This written representation forms the response from the NFFO and WFA-CPC to key documentations of concern to the fishing industry as part of the examination of the Morgan offshore wind project generation assets.

The response below is in response to specific concerns we have with regards the outline Fisheries Liaison and Co-existence Plan (FLCP).

Fisheries Liaison and Coexistence plan

Figure 1.2: Morgan Generation Assets lines of communication.

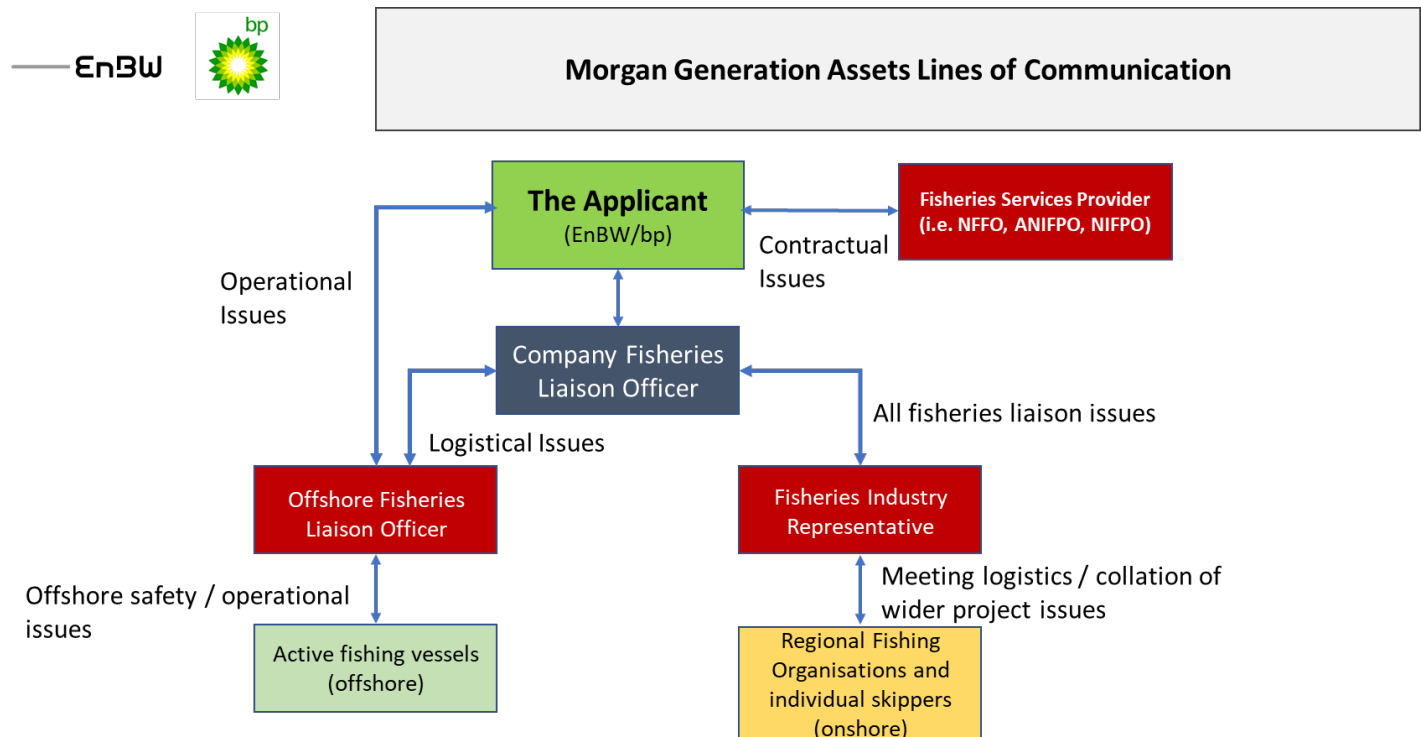
1.1.1.14 Figure 1.2 describes the NFFO as a fisheries service provider. The NFFO only act as a Fisheries Industry representative under fisheries liaison. NFFO Services act as a Fisheries Service Provider but this is a separate company to the NFFO, this change is requested for clarity in Figure 1.2.

Figure 1.3: Indicative location of Scallop Mitigation Zone.

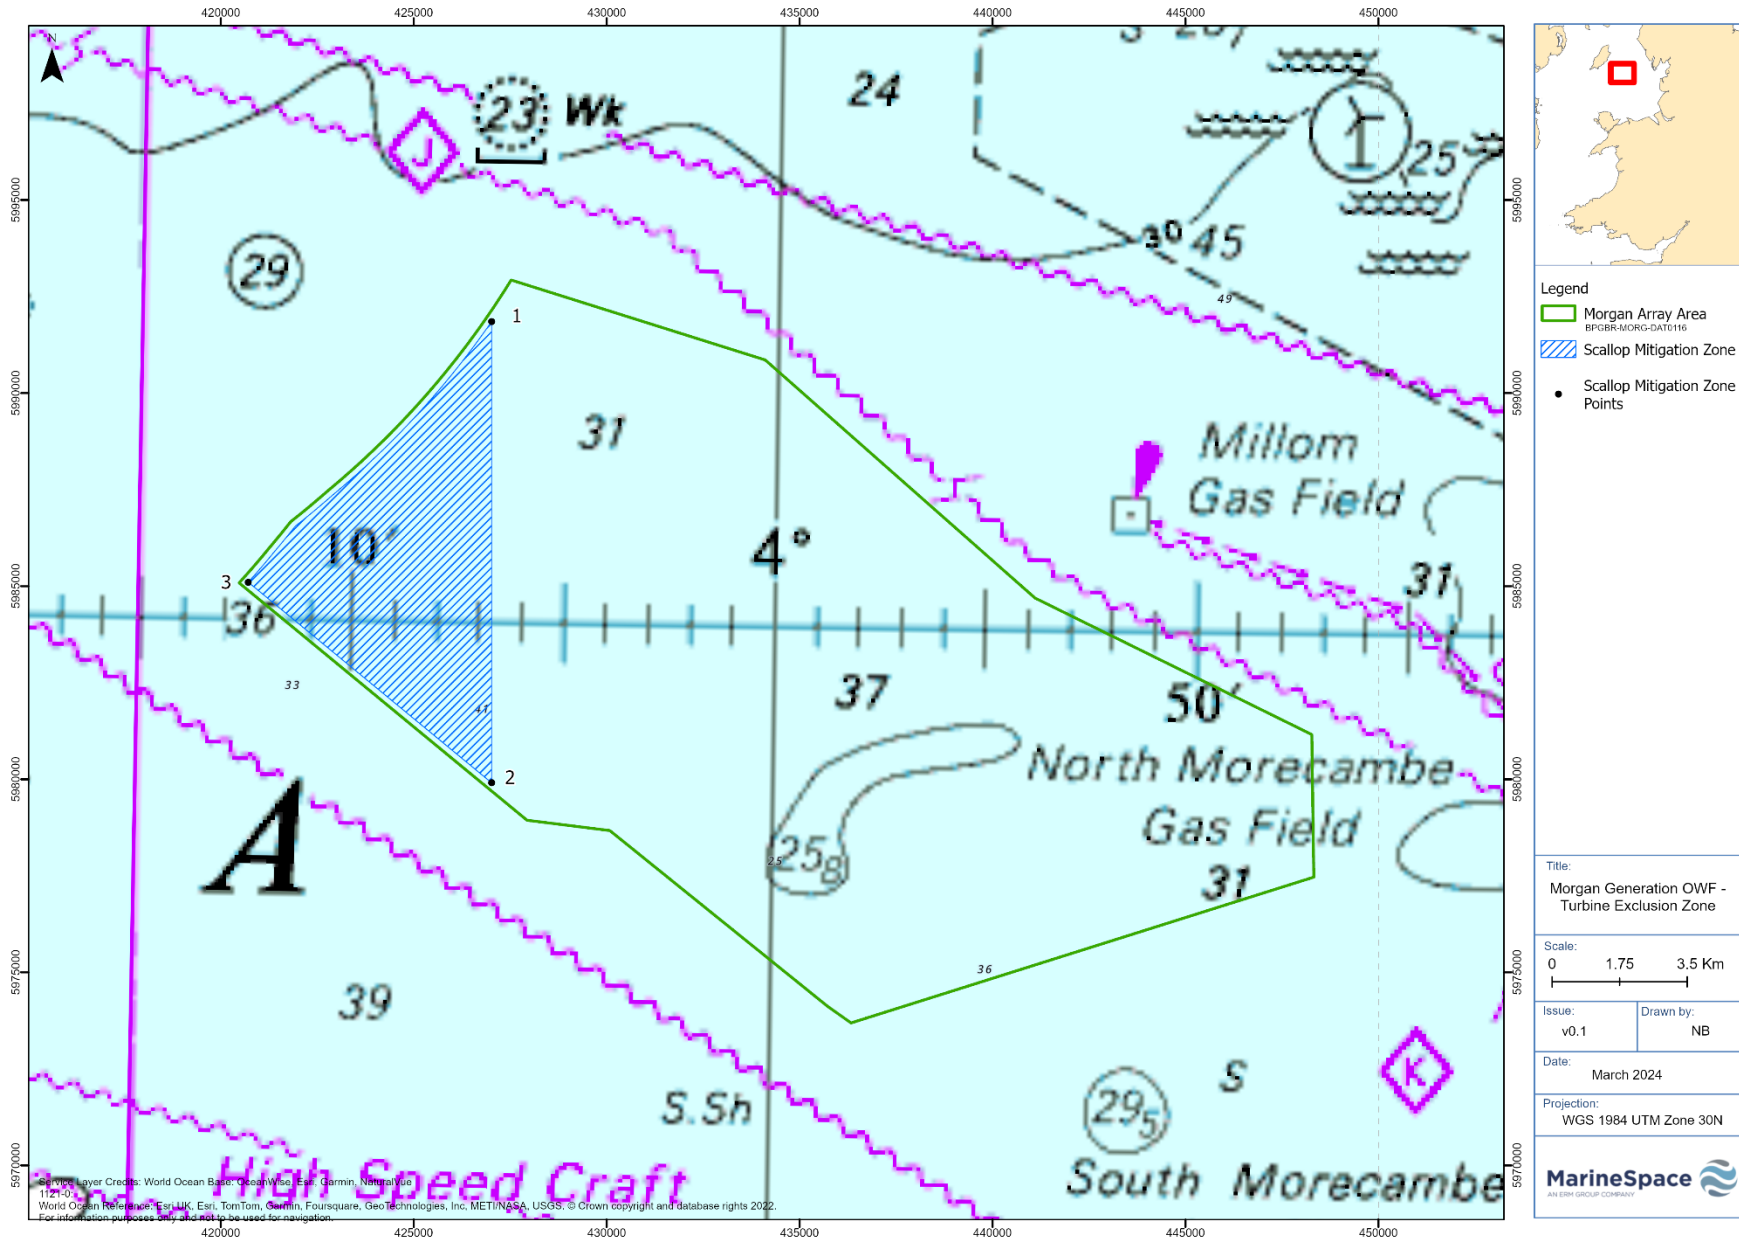
Table 1.2. The mitigation of a scallop mitigation zone is welcomed. However it is essential that for scallop fisheries to return to fish the area, cables are laid in a manner that will facilitate this mitigation.

1.35 The minimisation process of a scallop mitigation zone is welcomed. However, it is essential that for scallop fisheries to return to fish the area, cables are laid in a manner that will facilitate this mitigation.

1.1.1.38 For true mitigation and use of the scallop mitigation zone (SMZ), the burial depth of cables in this area is of paramount importance. A possible minimum cable burial depth of 0.5m will only allow for approximately 0.2m clearance between the maximum penetration depth of a scallop dredge and the cable asset. We would expect, for asset protection, and to reduce snagging risk, this minimum depth is avoided in the SMZ.
